National Highways Planning Response (NHPR 25-01) Formal Recommendation to an Application for Planning Permission

Council's Reference: 2026/0420

Location: Land west of Sheffield Road, Birdwell, Barnsley

Proposal: Erection of 10no. 2 and 3 storey detached dwellings

Engineering Plan

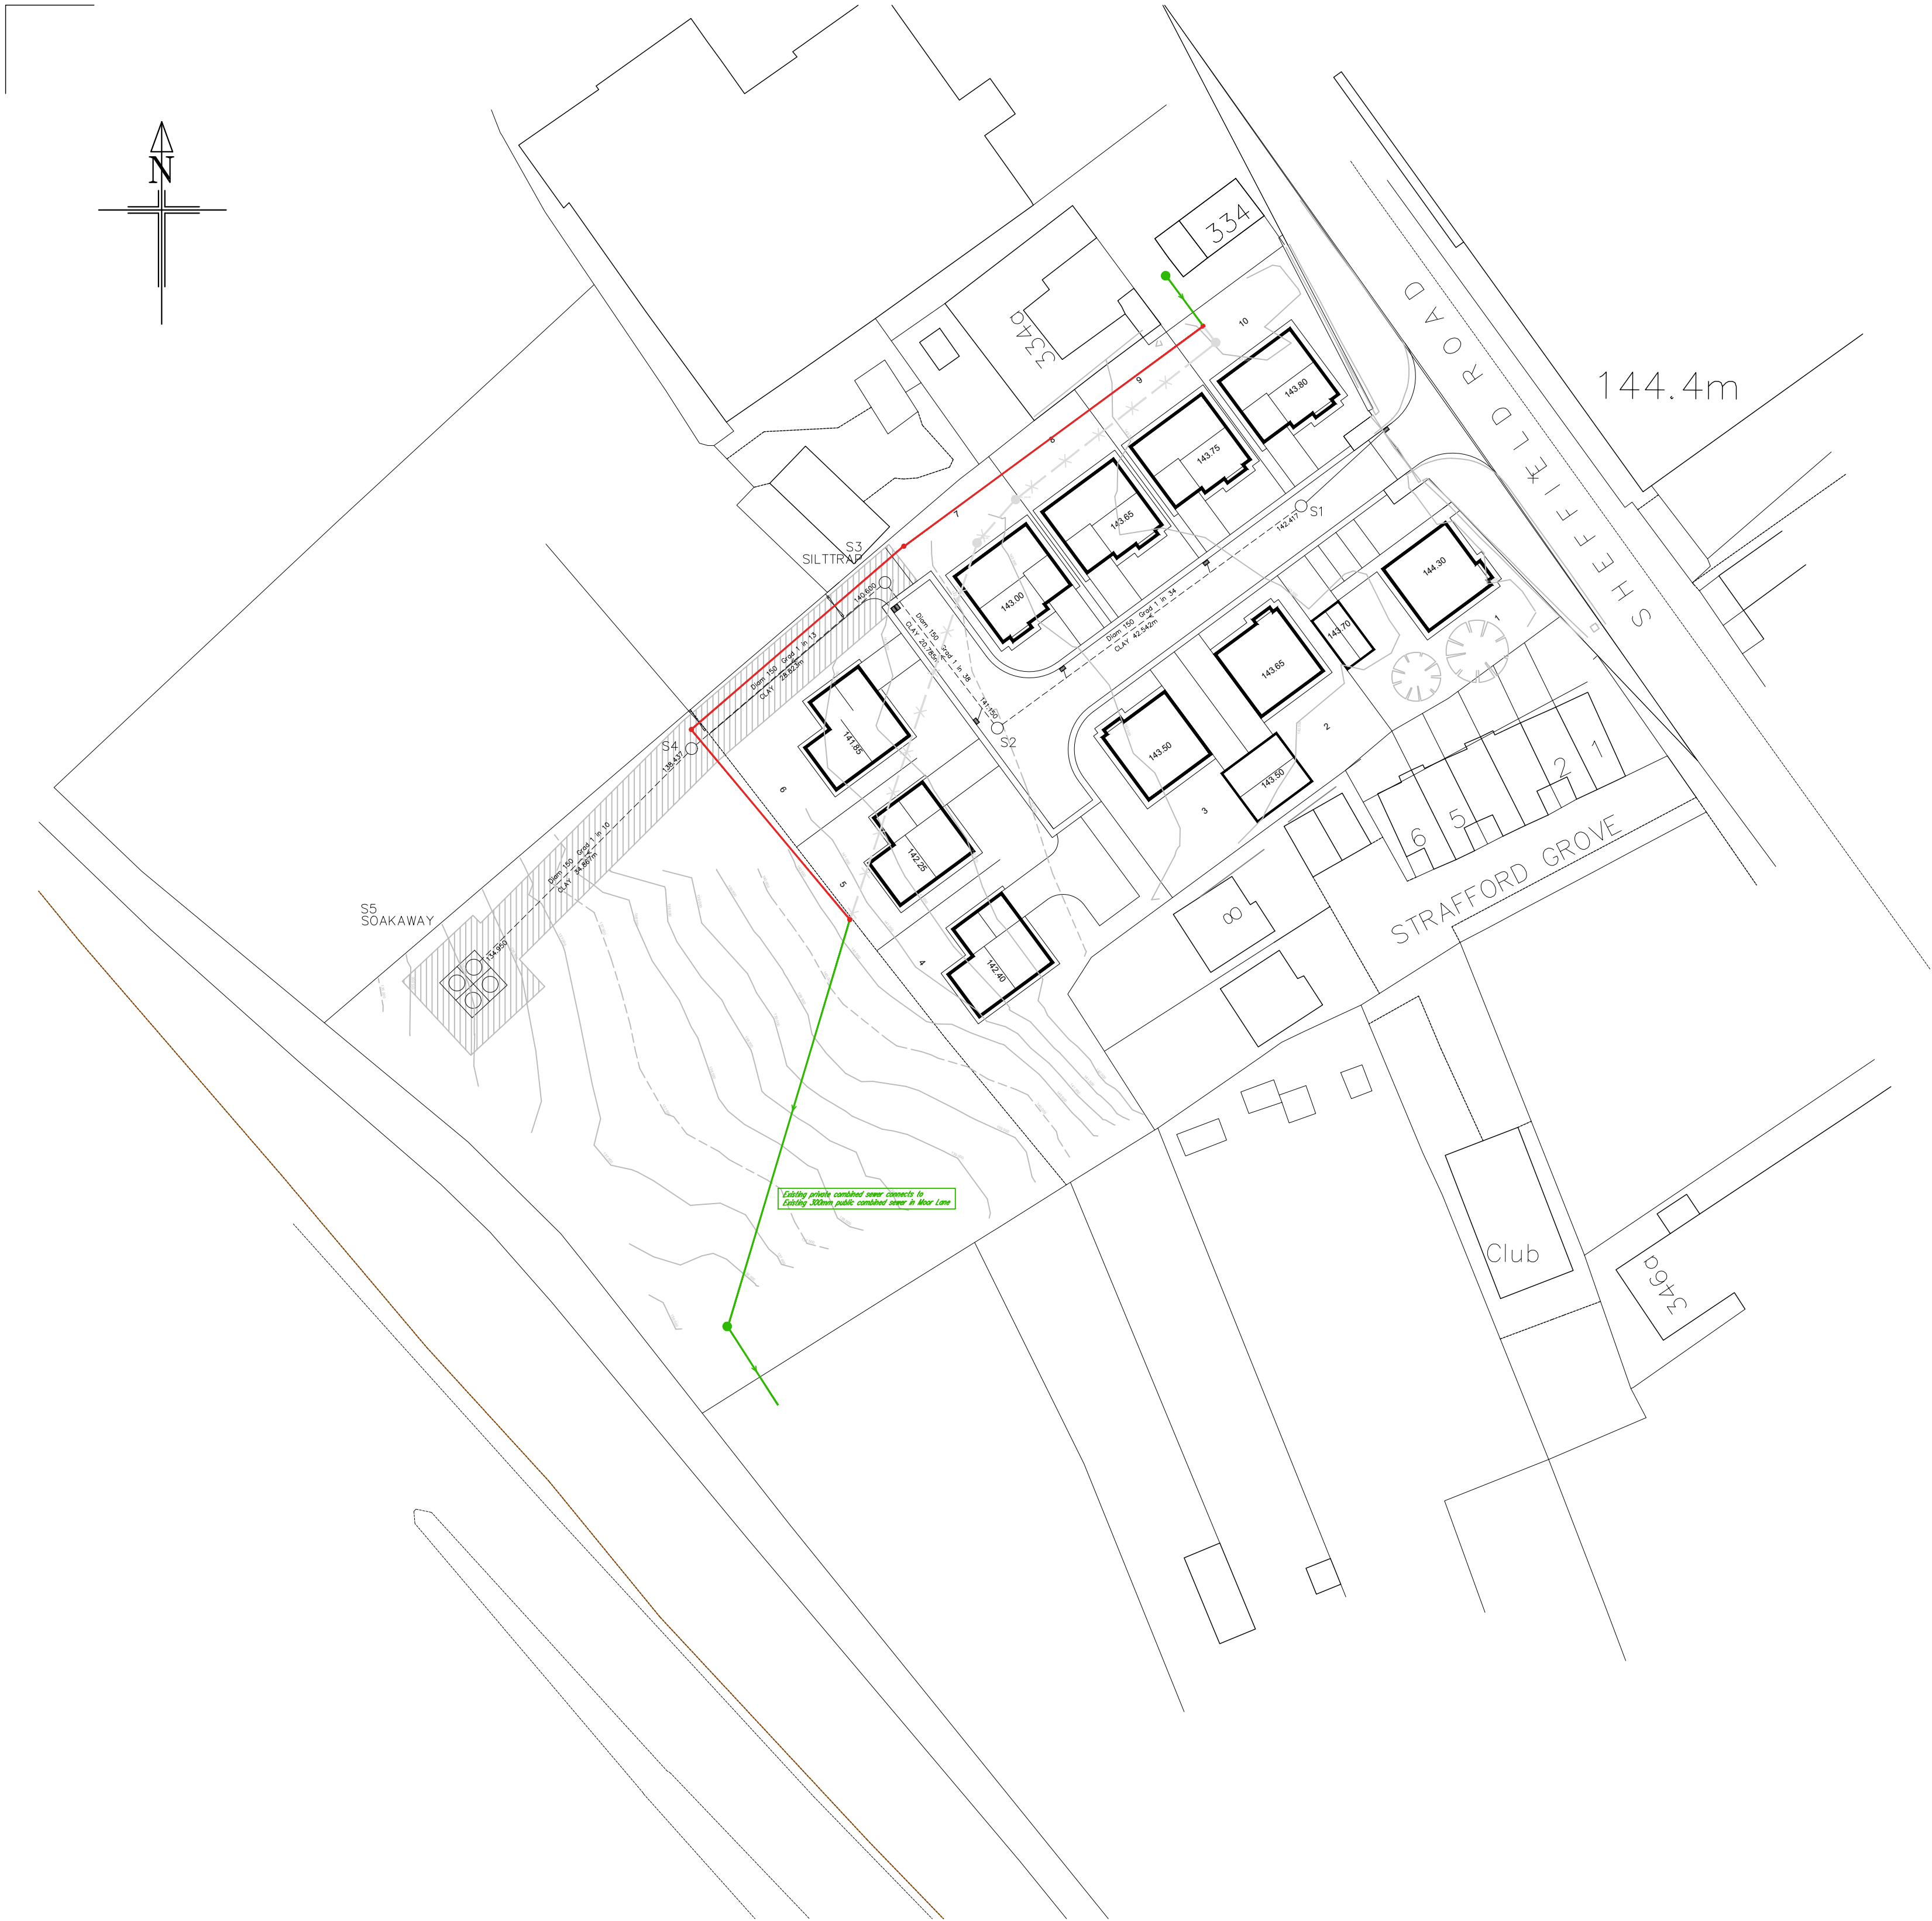
It is noted from the submitted planning application that surface water is proposed to be drained to soakaway on land outside of the red line boundary. Clarity on this is required, in particular on whether this has the potential to affect the delivery of the proposed drainage solution.

Notwithstanding this, whilst the private soakaway calculations appear to evidence that the soakaway can accommodate the proposed volumes both National Highways and Barnsley highway drainage team are concerned with the proposed location of the soakaway relative to the motorway embankment. It is particularly important that any risks associated with this are fully explored and can be appropriately mitigated.

Based on the above, I recommend that the application is not determined until clarity on the red line boundary is resolved, in particular whether this should be expanded to include the soakaway which this development relies upon. And allow for discussions to take place regarding the location of the soakaway and any potential impact this may have on National Highways assets has been fully explored.
